From: [REDACTED] >
Sent: 21 August 2020 09:16
To: A303 Stonehenge
Subject: A303 Stonehenge Tunnel supplementary consultation

Following the recent archaeological discoveries at Stonehenge, I would like to make the following comments re; the current Berwick Down to Amesbury A303 scheme. In my opinion three things need to be addressed. These are;

Drawing Title
STRUCTURES DRAWINGS
WESTERN TUNNEL PORTAL
REGULATION 5(2)(o)
SHEET 8 OF 13

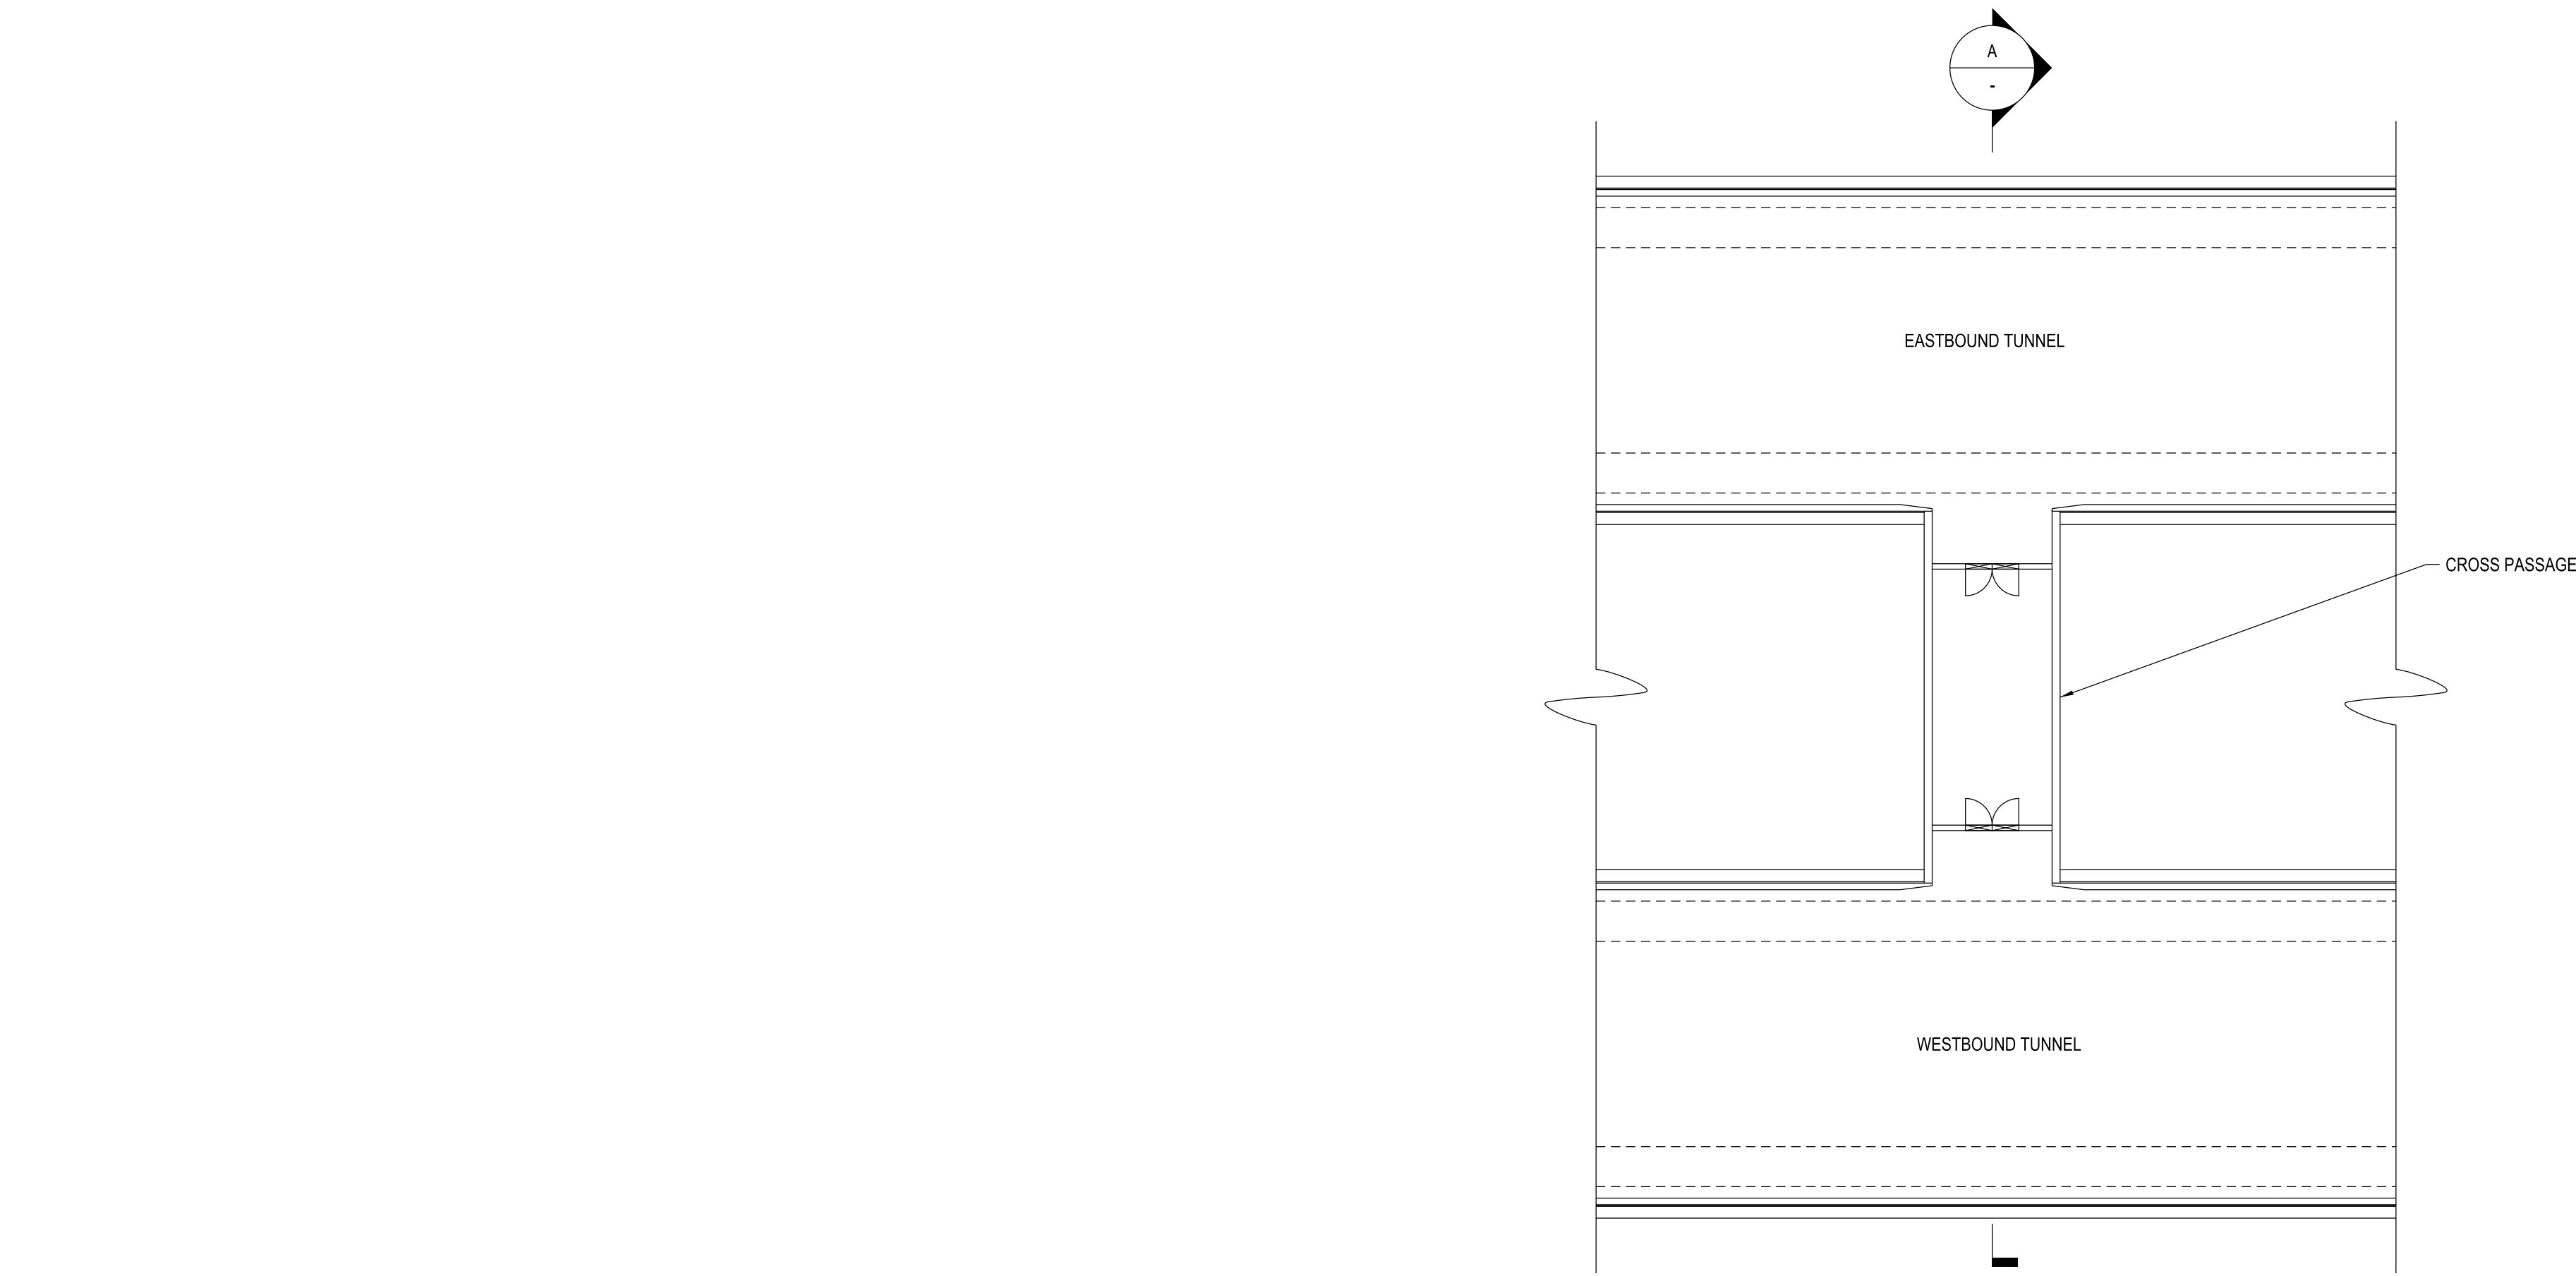
GREEN BRIDGE no. 3a Designed to reduce the
bridleway footprint and provide extra coverage to
the western portal cutting. The capacity of this
bridge would be transferred from Green Bridge
no.2 which would be built as a standard bridge

Drawing Title
STRUCTURES DRAWINGS
EASTERN TUNNEL PORTAL
REGULATION 5(2)(o)
SHEET 11 OF 13

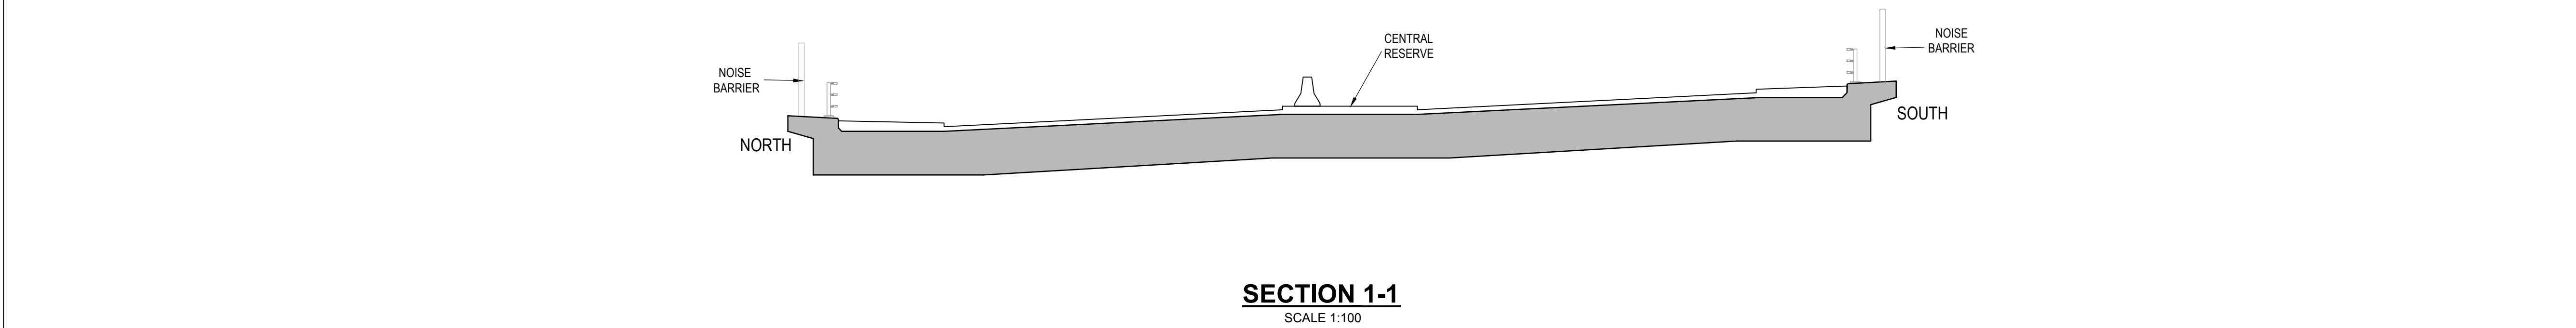
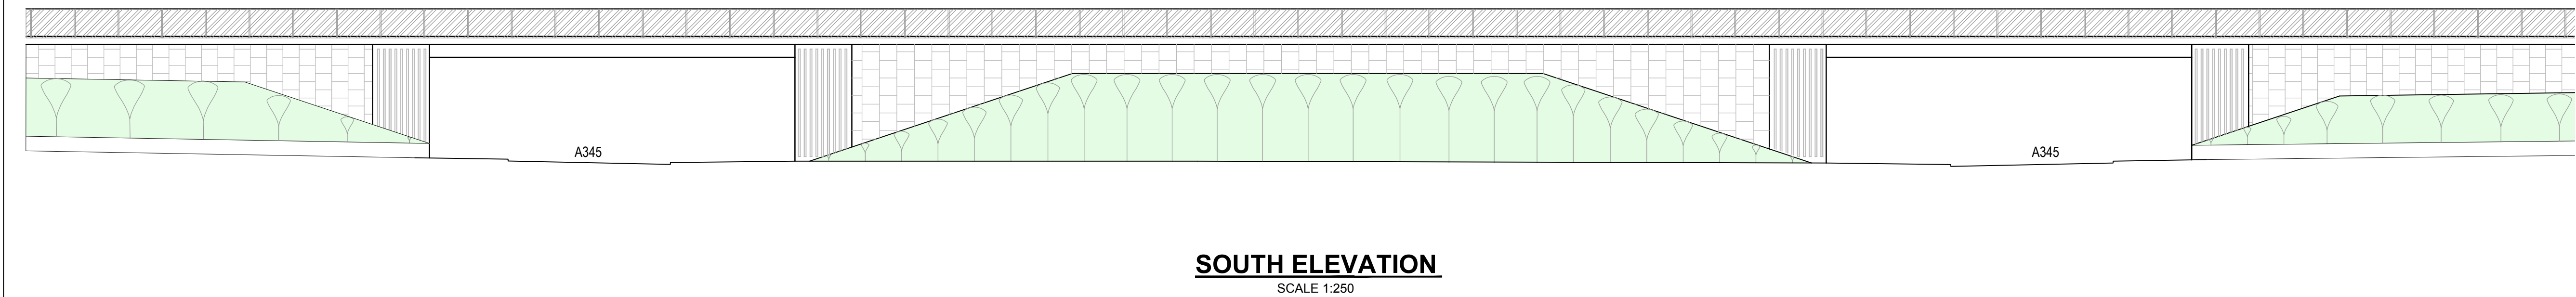
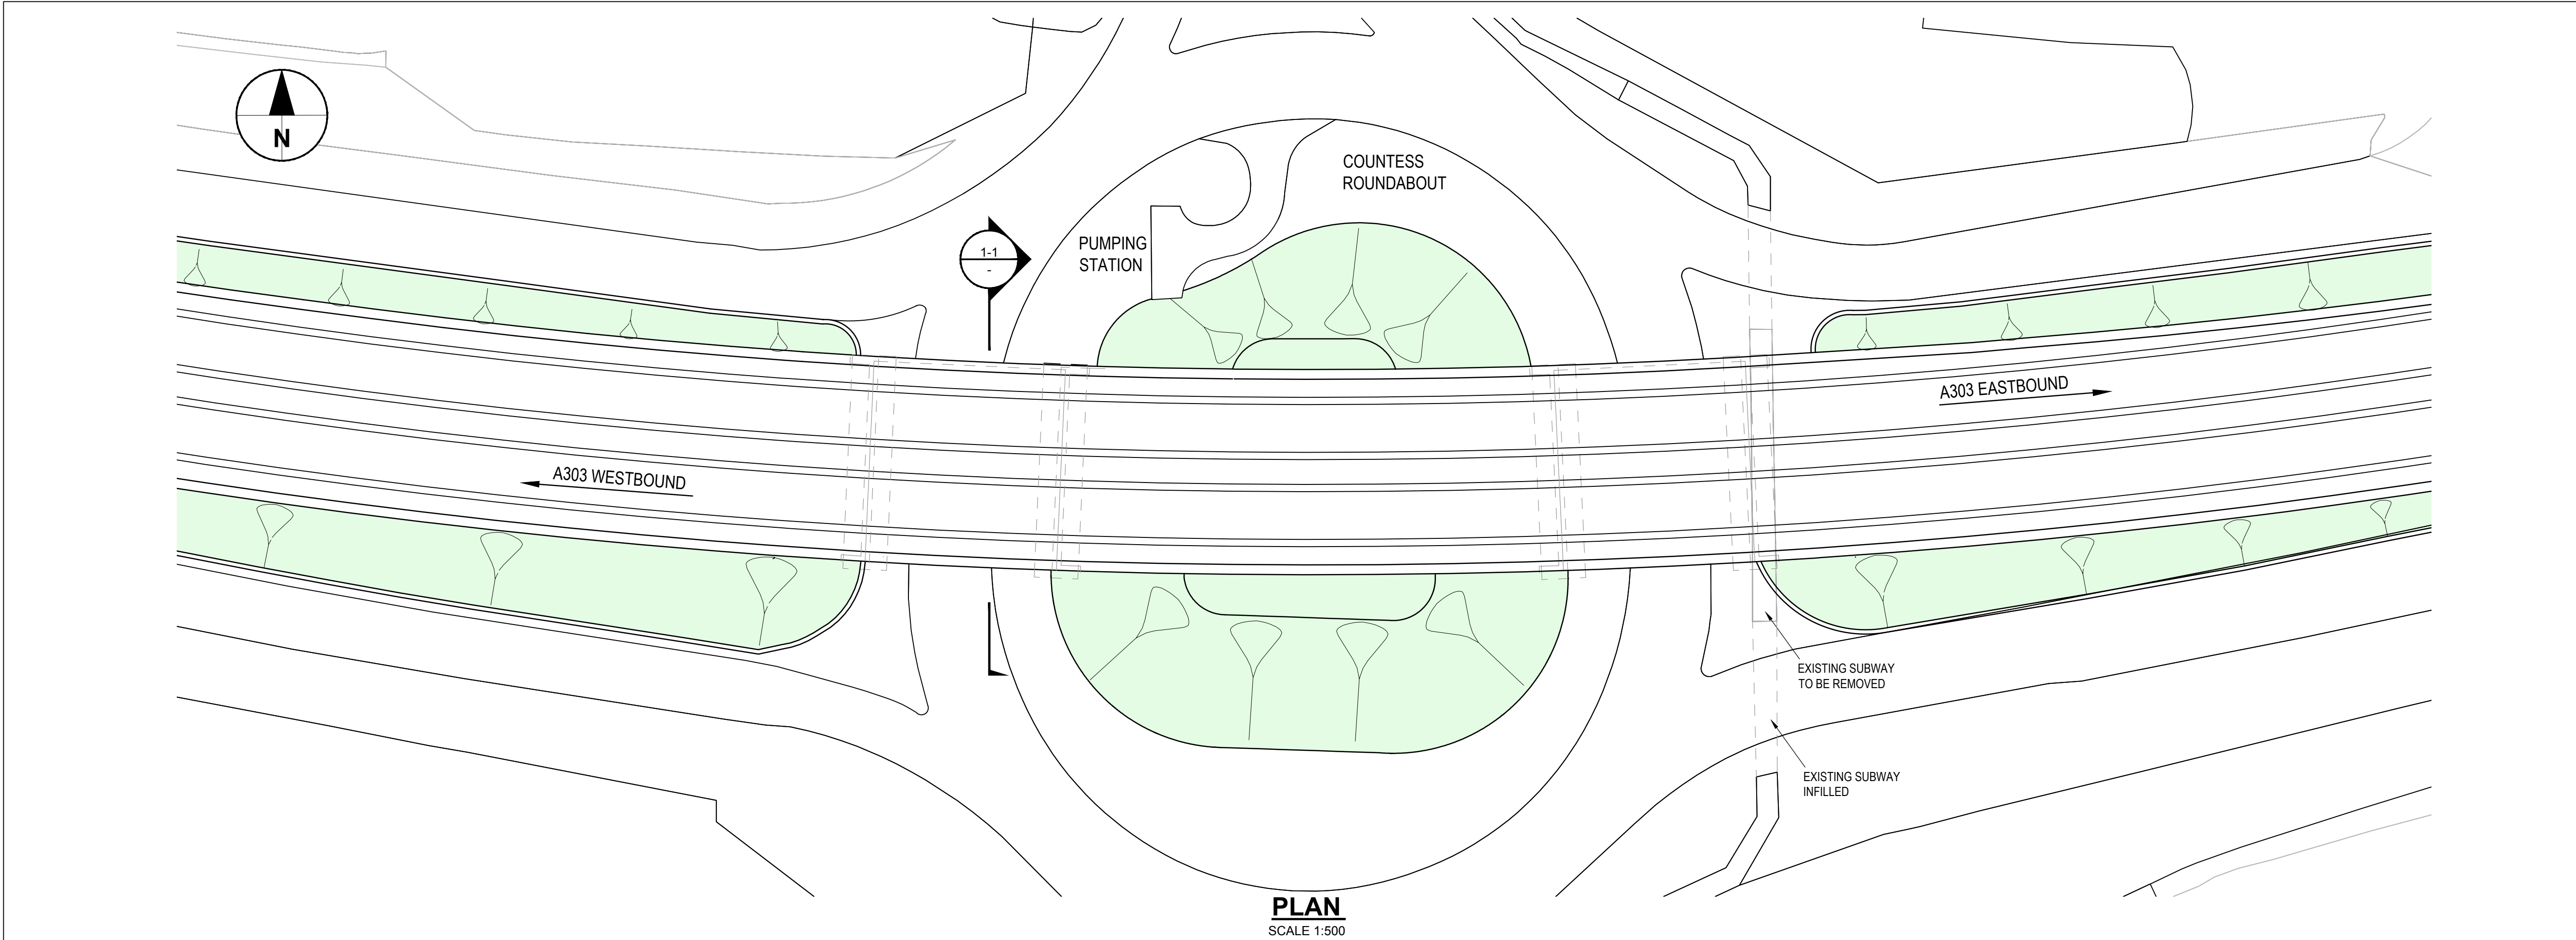
1. The eastern tunnel portal needs moving onto the line of the current road. Taking a large chunk out of the WHS, near to where the discoveries were made, is unacceptable.
2. The line the man tunnel bore needs moving or slewing about 50m to the south. The current line just south the surface A303 is still too near the stones.
3. Finally, there needs to be an extra green land bridge crossing the line of the proposed A360 bridleway. The extra long green bridge proposed in the last consultation is welcome, but more needs to be done. This could easily be achieved by moving the capacity of Winterbourne Stoke bypass green bridge no2 into the WHS and building that bridge as a simple steel and concrete structure.
